From: Sue Howell
Sent: 20 March 2018 17:10
To: Planning.Responses
Cc: Anita Gardner
Subject: FW: Planning Consultation on: FG/206/17/PL

Comments from Greenspace

Further to the submission of Landscape Plan A-17-31-FW dwg 200-06 Rev A, I can comment as follows.

Registered: 24th January
 2018
Site Address: Land at Asda Superstore Littlehampton Road
 Ferring BN12 6PN
Grid Reference: 508801 103369
Description of Installation of a Six Pump (12 Filling Position)
Works: Petrol Filling station, Drive-to- Pay Kiosk &
 associated works including Jet Wash, Air/ Water
 Services & Vacuum Equipment

1731FW CA S0 00 00 A 200_06 S4 B Landscape Plan

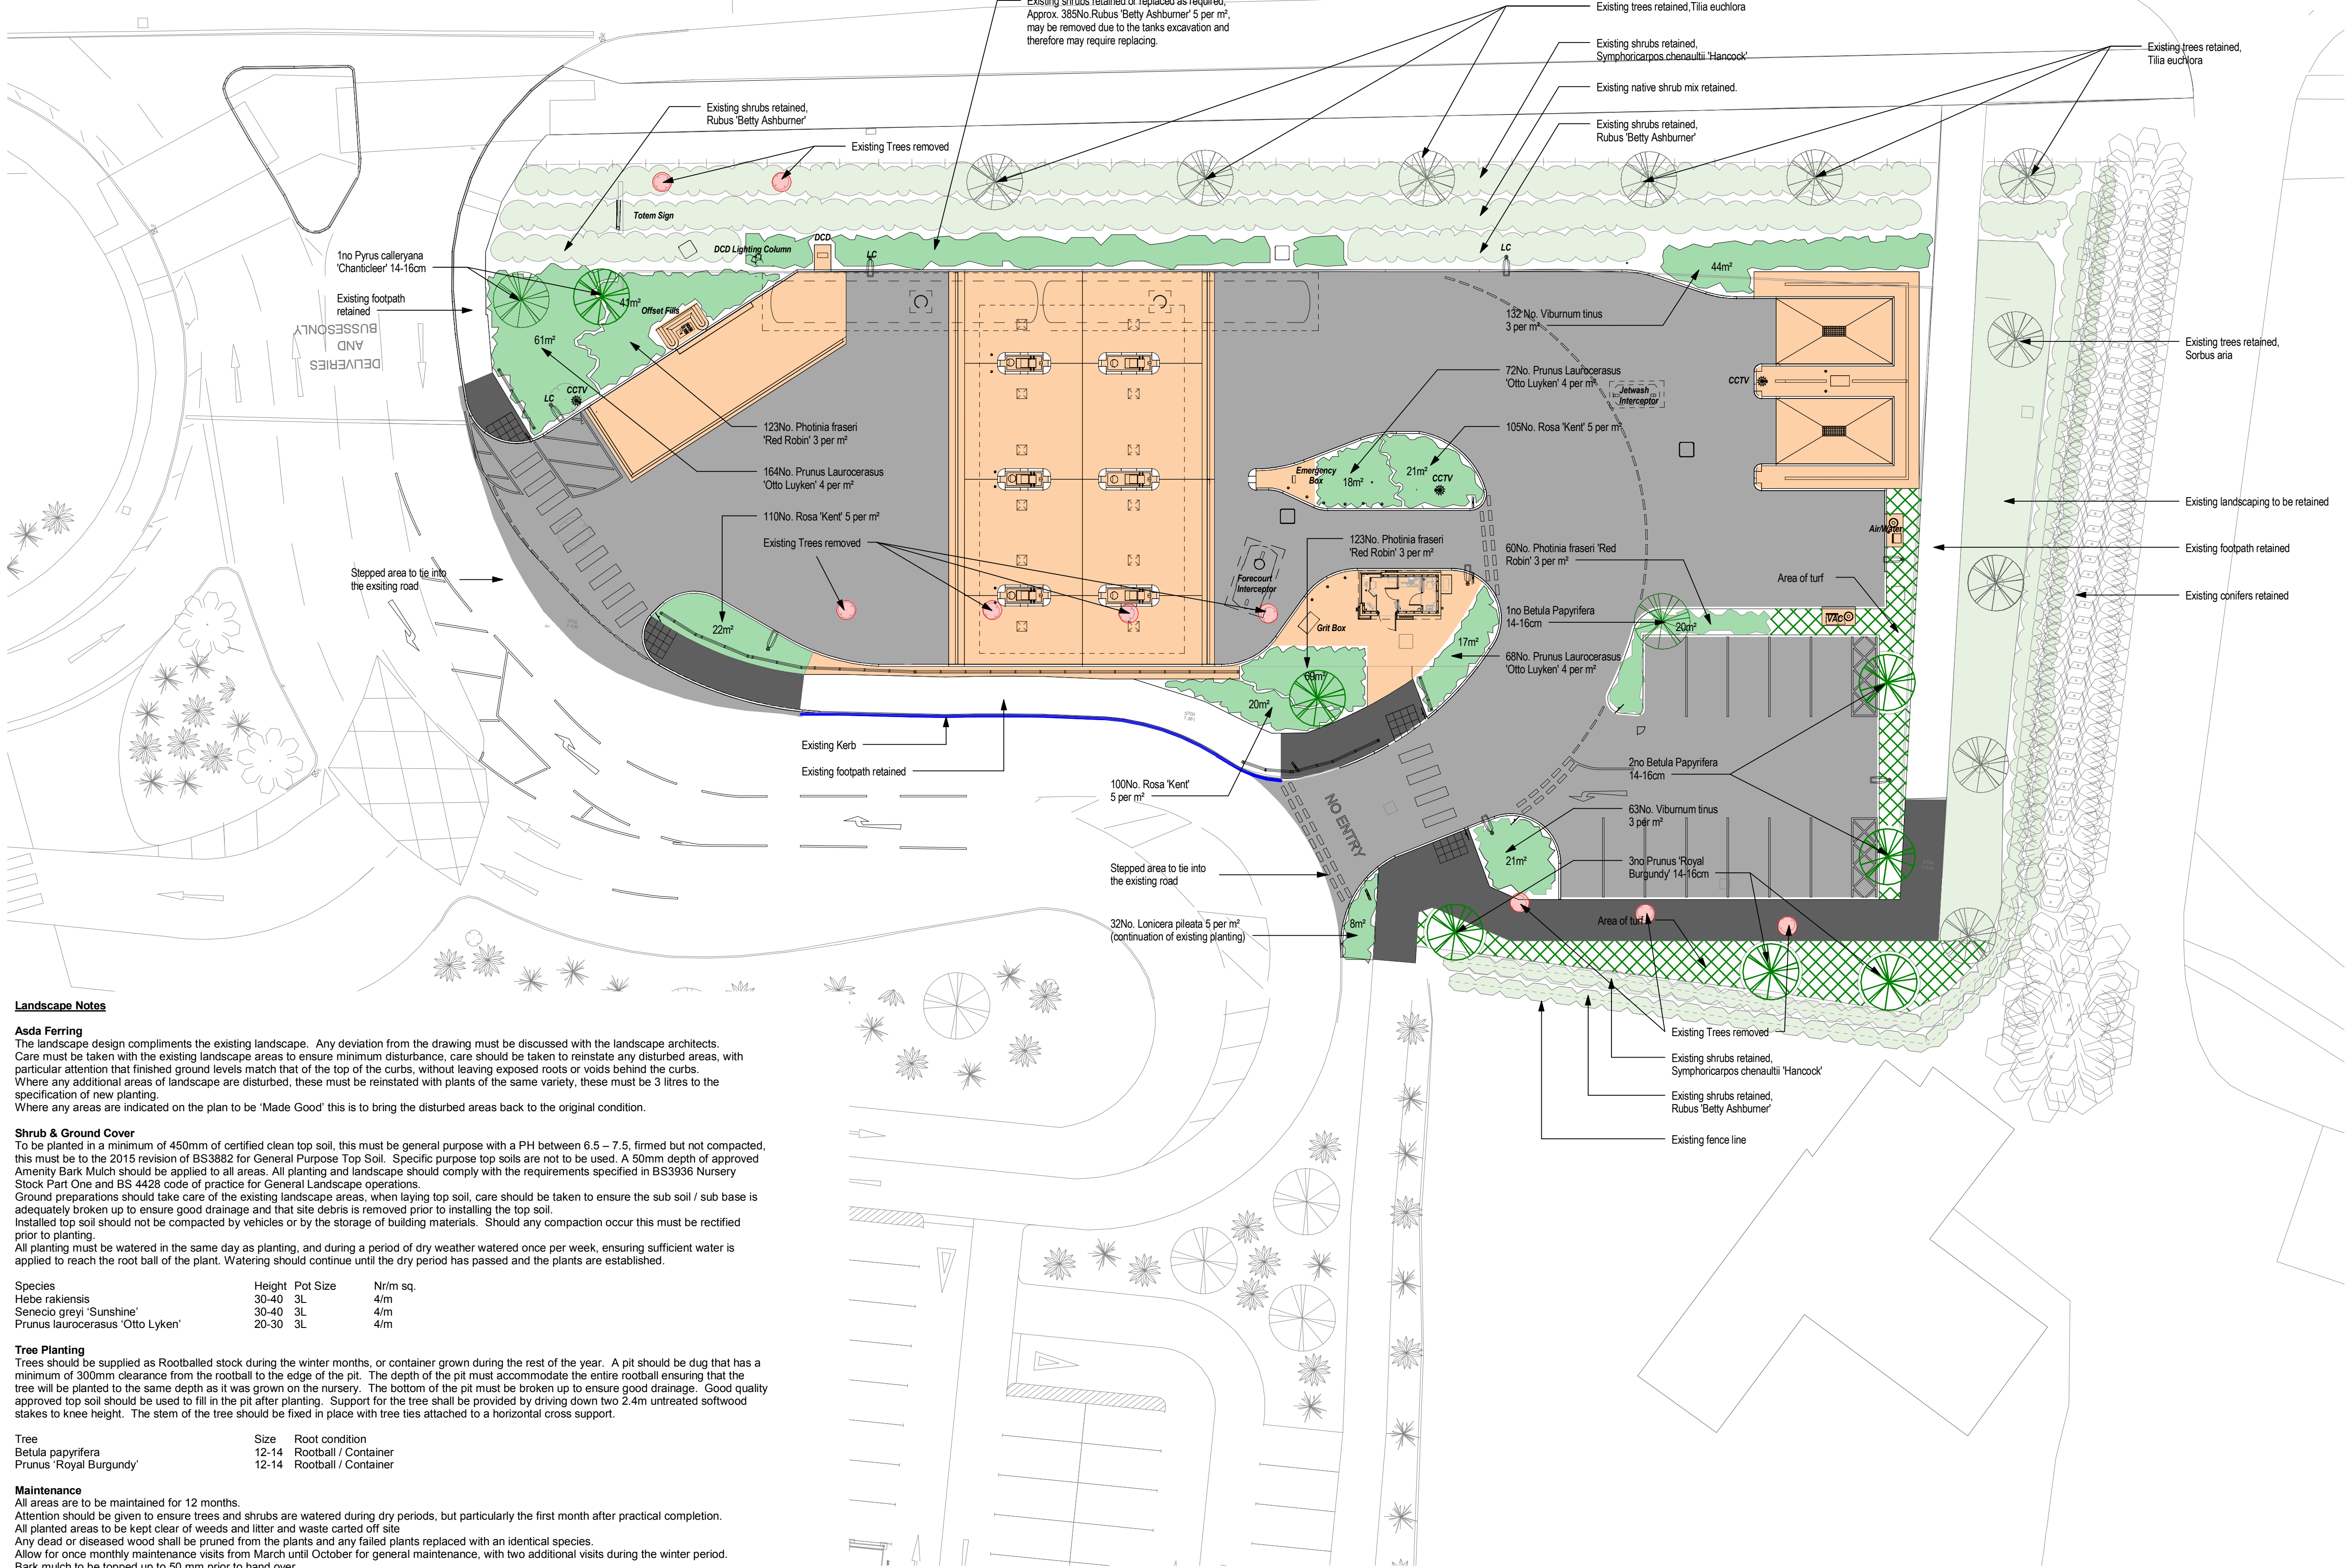
The proposed site contains an existing and establishing planting scheme implemented at the time of the ASDA store. This planting is establishing well and contains a mix of trees and shrubs both evergreen and deciduous which in context are adding value to the location. This planting appears to have been disregarded within the proposals in particular the hedging to the south eastern boundary which is to be lost to a pathway with the proposals as shown. Juvenile yet establishing trees also in this location and within an existing central island planting bed will also be lost if the proposals go ahead as detailed.

The proposed planting scheme contains plant species which would be considered more ground cover ie Hebe and Senecio rather than adding landscape structure planting, without any screening value. The trees indicated are also at a smaller size at 12-14cm girth to those in existence.

My recommendation is that the proposed landscape scheme is inadequate regarding what would need to be removed in order to implement these proposals. The planting proposals are not replacing on a like for like basis and is providing no mitigation to compensate for the new use of this area. These proposals will cause impact to local residents and will also be seen from the wider area particularly from the SDNP to the north. Further landscape detail should be considered and incorporated into this proposal in order for the landscape value and the impact on its surrounds not to be compromised.

I would recommend an objection on landscape grounds to the proposals at present which could be overcome with a more thoughtful and complete landscape proposal. I would recommend that further landscape detail is submitted for approval or conditioned along with any decision.
